**Consultation Response from KC,
Lead Local Flood Authority**

2026/90604 The Bridge, 159-161, Manchester Road, Longroyd Bridge, Huddersfield, HD1 3LE

Change of use of public house ground floor and basement to dental clinic and taxi office

Date Responded: 24th June 2026

basement floor plan

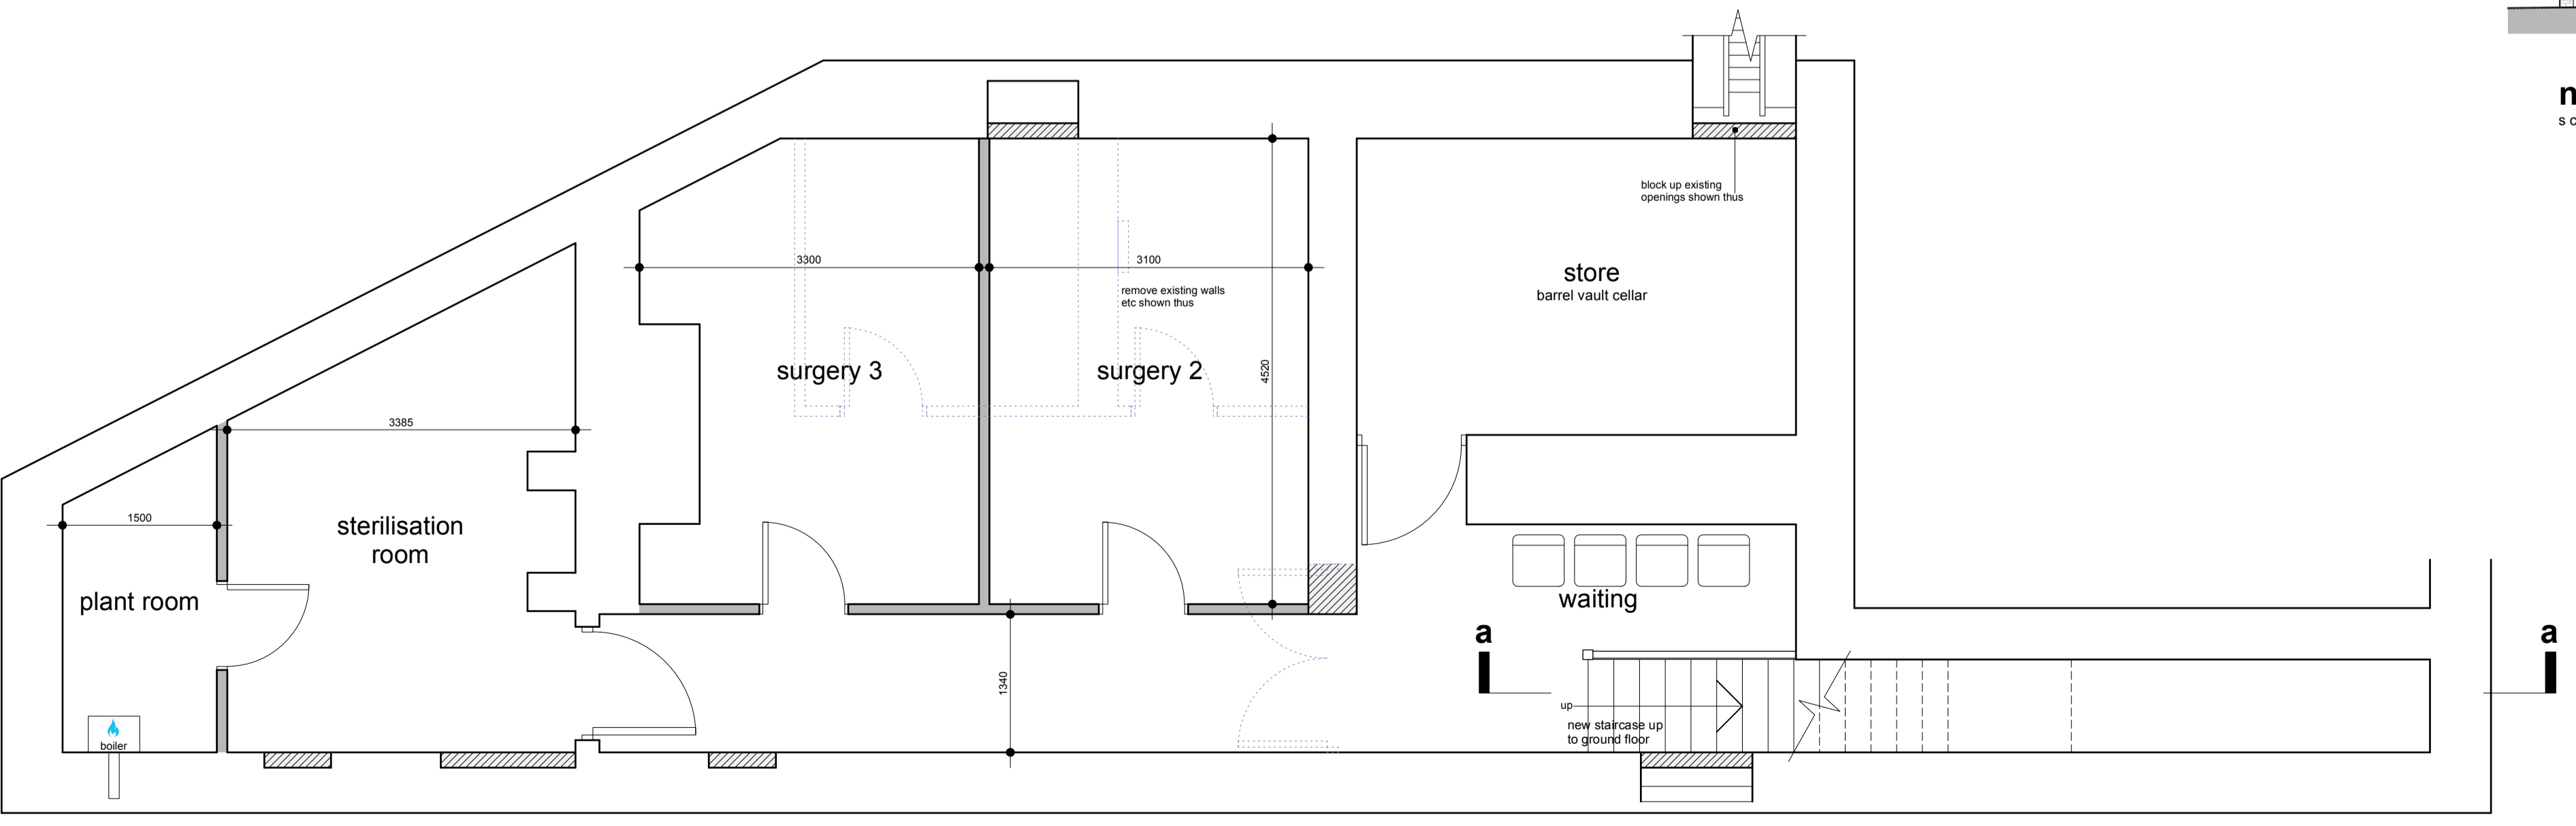
The new use for the building overall has a vulnerability of classification of 'more vulnerable' (non-residential occupation for health services), and the use of the lower ground floor is changed to active, and the Flood Risk Assessment should have taken into account this change and consider **'the safety of people within buildings'**.

The FRA is reliant on mitigation of flood risk and cannot achieve finished floor levels 300mm above the flood level with climate change added.

We conclude therefore that the use of the basement, both active use compared to previous and what it is used for (more vulnerable) increases flood risk and therefore we OBJECT. Mitigation methods are therefore inappropriate as they would be considered actions against 'residual risk', where as the planning authority has the opportunity to avoid this risk.
